KIRKLEES METROPOLITAN COUNCIL INVESTMENT & REGENERATION SERVICE

Reference No:	2022/44/92621/E
Site Address:	23, Fall Lane, Hartshead, Liversedge, WF15 8AP
Description:	Discharge conditions 3 (materials), 5 (Phase 1 Desk Study Report), 6, 7 (Phase II Intrusive Site Investigation Report) 11 (noise), 12 (boundary treatments) on previous permission 2022/90223 for variation condition 2 (plans and specifications) on previous permission 2021/92116 for erection of detached dwelling and single and two storey rear extension to existing dwelling
Recommending Officer:	Callum Harrison

DECISION – APPROVE DISCHARGE OF CONDITIONS

Application: 2022/92621 - 23 Fall Lane, Hartshead, Liversedge, WF15 8AP

PROPOSED BOUNDARY TREATMENT PLAN

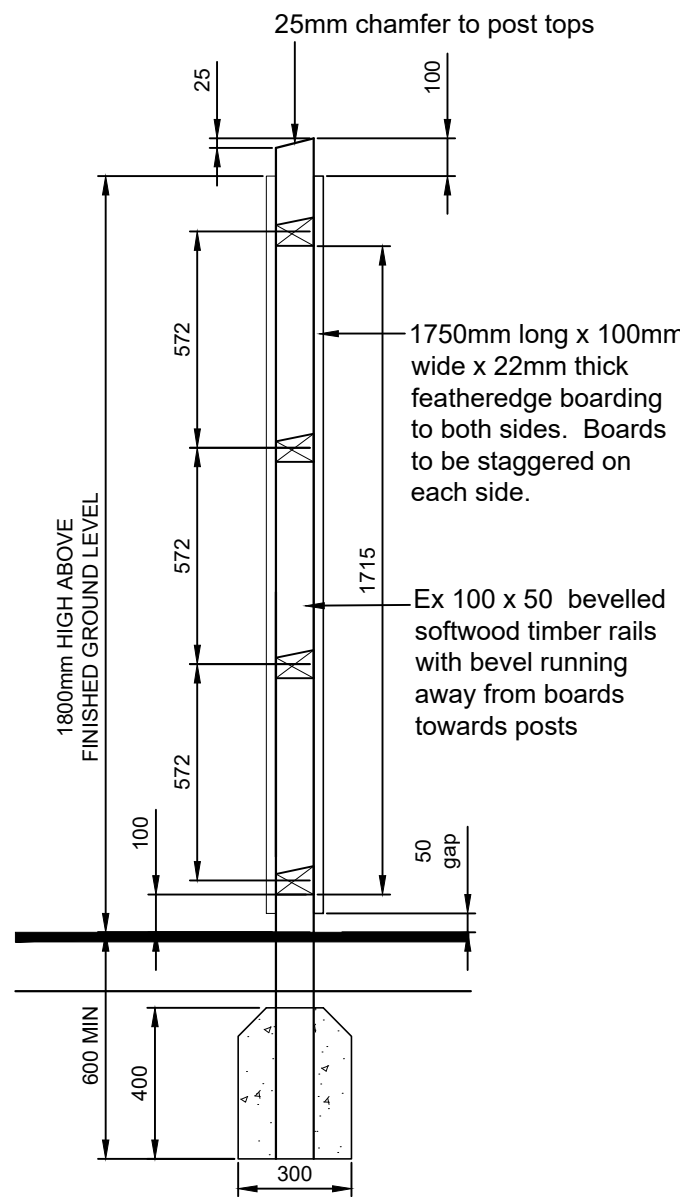
The proposed development will retain the existing walling and fence that fronts on to the highways. All new fences and boundary treatments are within the site and not set fronting on to the highway. All of the boundary treatments proposed are 1.8m or less. The final development would see a combination of existing and proposed fencing, hedgerow, timber gates and rendered retaining wall to bound the site. The proposed boundary treatments would accord with policy set out in the condition in respect to visual amenity and create a high quality finish when complete. As such, condition 12 can be considered discharged for the purpose of the pre-commencement condition, however, the development must now be completed in accordance with the approved details before the dwellings are first brought into use and thereafter retained.
